Memorandum

Re: Ledgewood Drive 16 Lot Subdivision (Old Barn Estates), 1062 Ocean Avenue
TPO Properties, LLC, Tim Donovan

Project #: 2012-584 **CBL:** 414-A-4 (Part within Town Of Falmouth)

Meeting Date: January 22, 2013

Plan 5 2nd wkshp

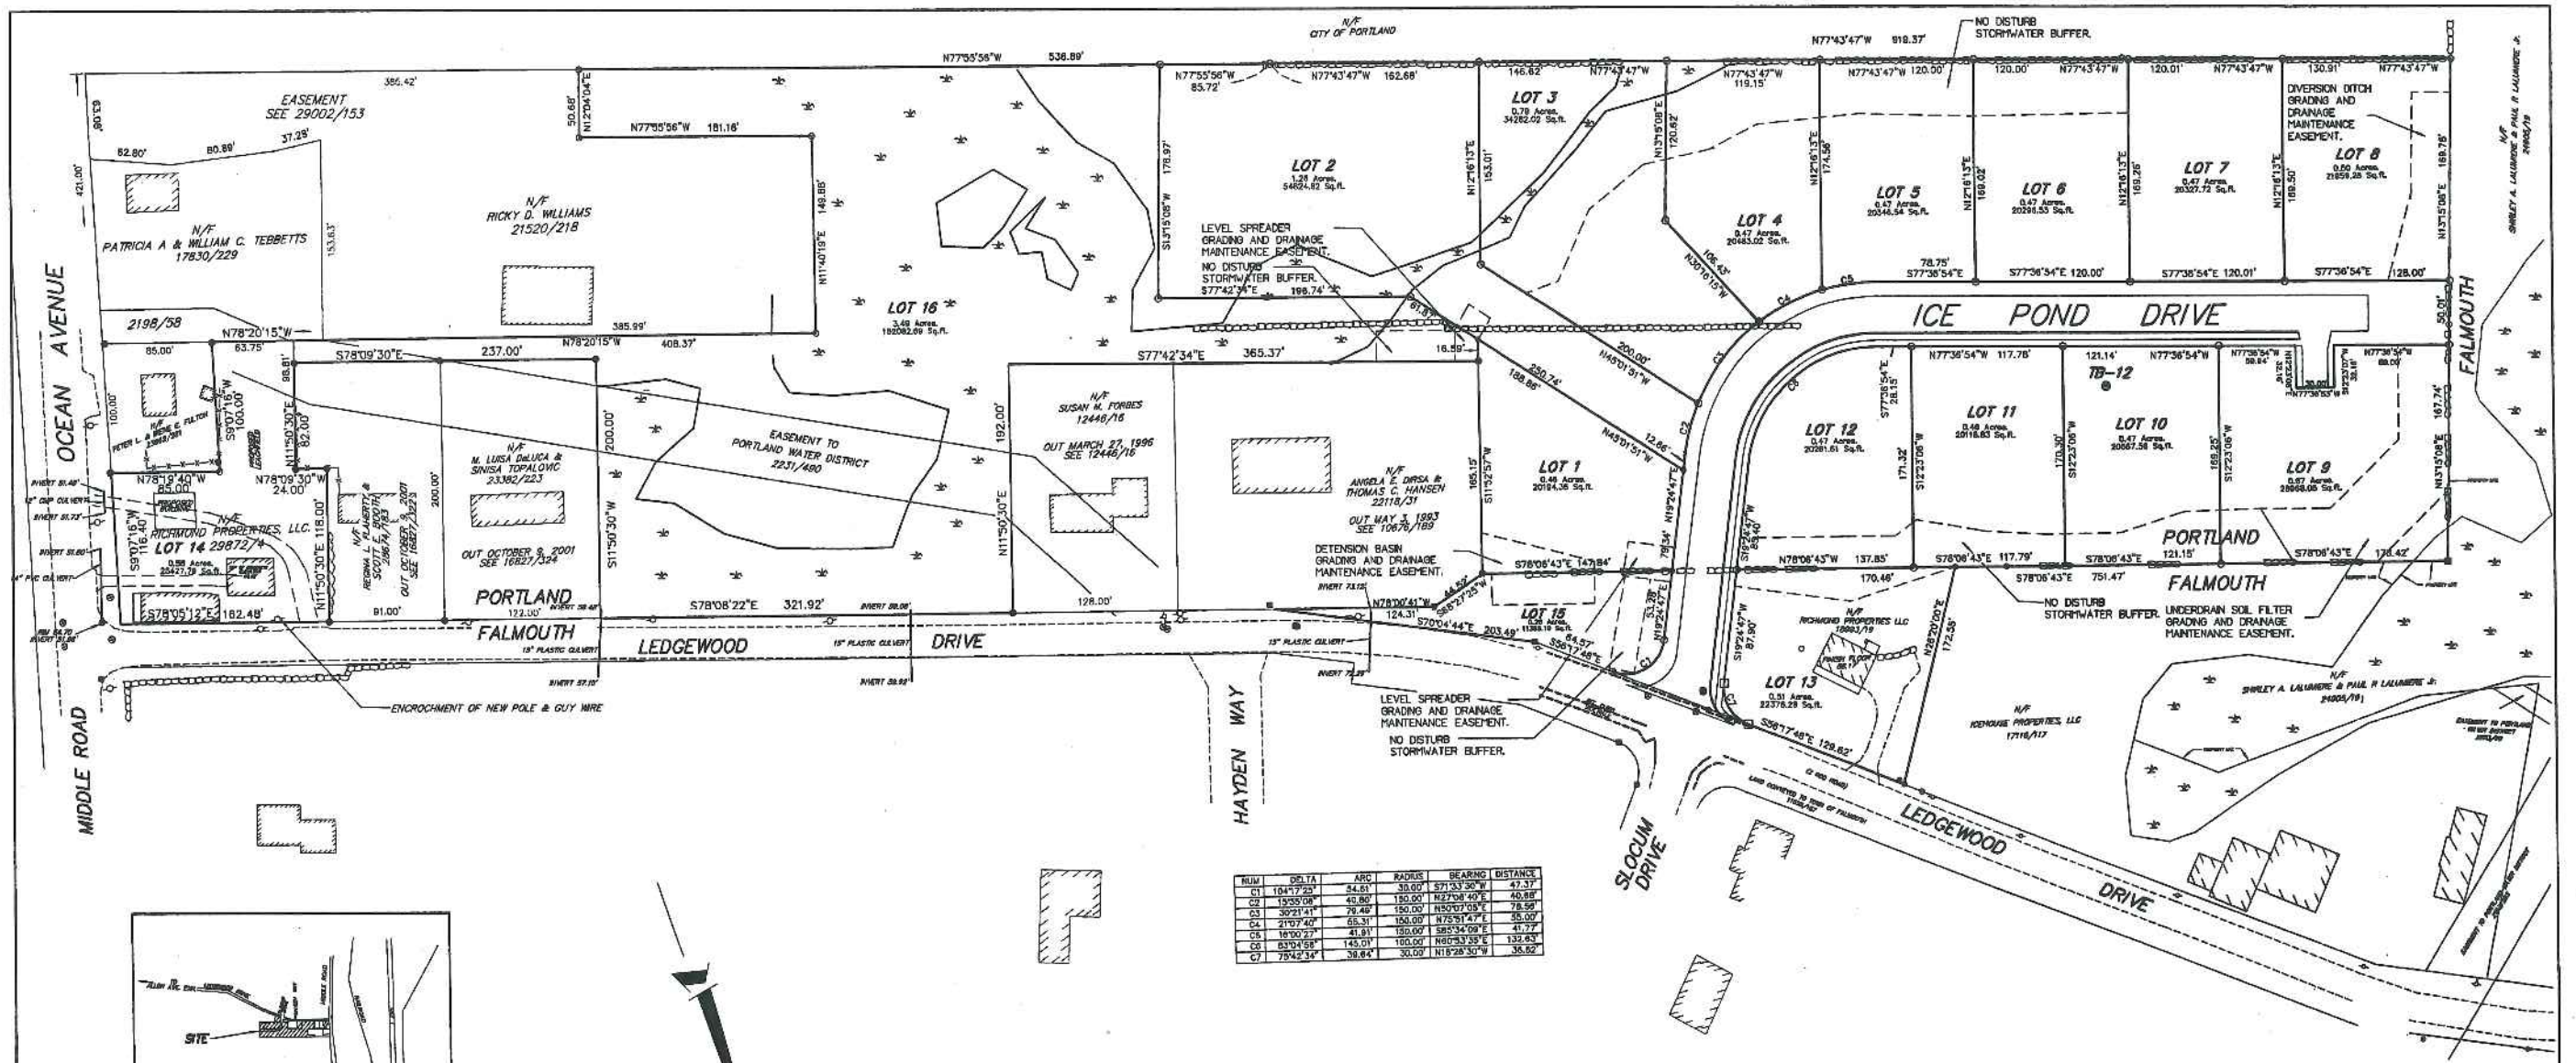
The draft Subdivision Plat is included as Plans 5 and 6. The graphic presentation is generally acceptable, but a number of notes will need to be added to clarify the status of the new street and its ownership, limitations on lots (tree zones; setbacks etc), responsibilities for maintaining common features/systems, etc.

Lot #14 has been shown and described as remaining in its existing condition but would need to meet any subdivision requirements (Attachment G and Plan Set). If those requirements are not shown on the plat at this time, there would need to be a note to this effect and the plat would need to incorporate any future development.

1 SUBDIVISION STREET (ICE POND DRIVE) CROSS SECTION
SCALE: N.T.S.

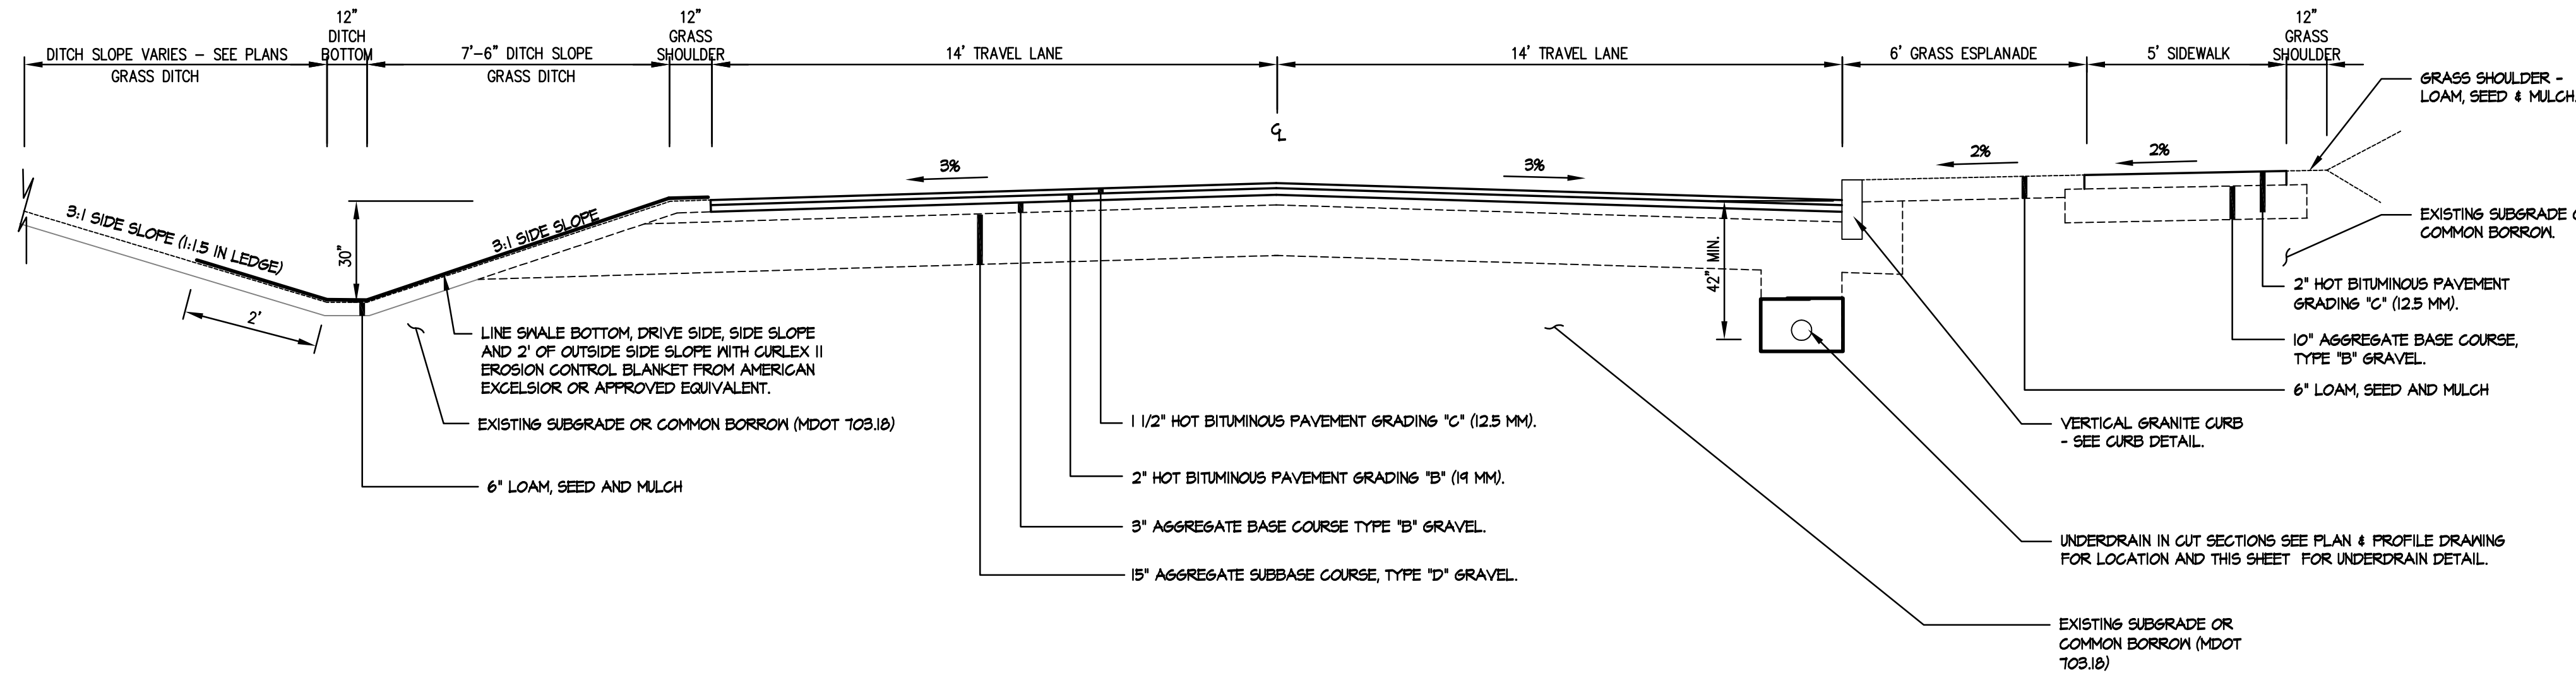
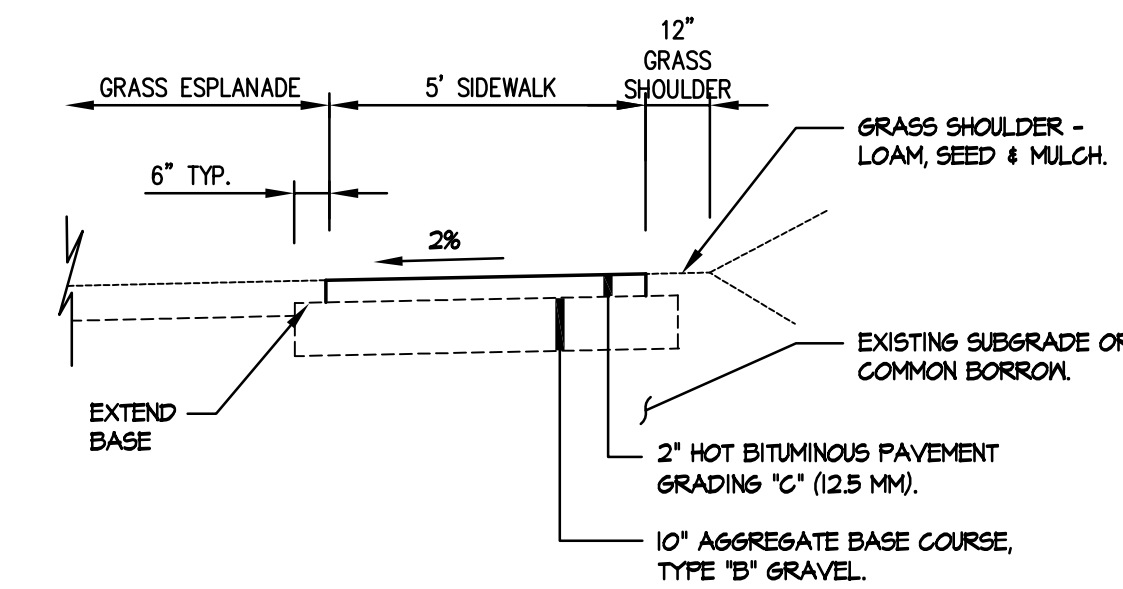
The access drive has been designed to meet City of Portland standards with a paved travel way of 28 feet in width. The standard in Falmouth is 24 feet and although the Falmouth Board has indicated it would defer to the Portland standard since it is anticipated to be a Portland street (Attachment 1b). The applicant did ask at a pre-application meeting whether a 24 foot wide road could be approved, but the Fire Department has indicated that 28 feet is needed for emergency access.

The proposed new street stops 63 feet short of site boundary and does not run along the full frontage of Lots 8 and 9. Lot #9 has both a turnaround and a maintenance access drive for the stormwater system in the front yard (Plan 7). Staff recommend that the street be extended across the entire frontage (to meet zoning requirements and to allow the sidewalk to be paved - as discussed in other sections of this memo) and to combine the turnaround with the maintenance access near the site boundary (Attachment 13).

1. Revise the Stormwater system to address the Engineering review comments
2. Revise new street to extend and modify turnaround location, extend paved sidewalk and address other detailed comments, and resolve street lighting
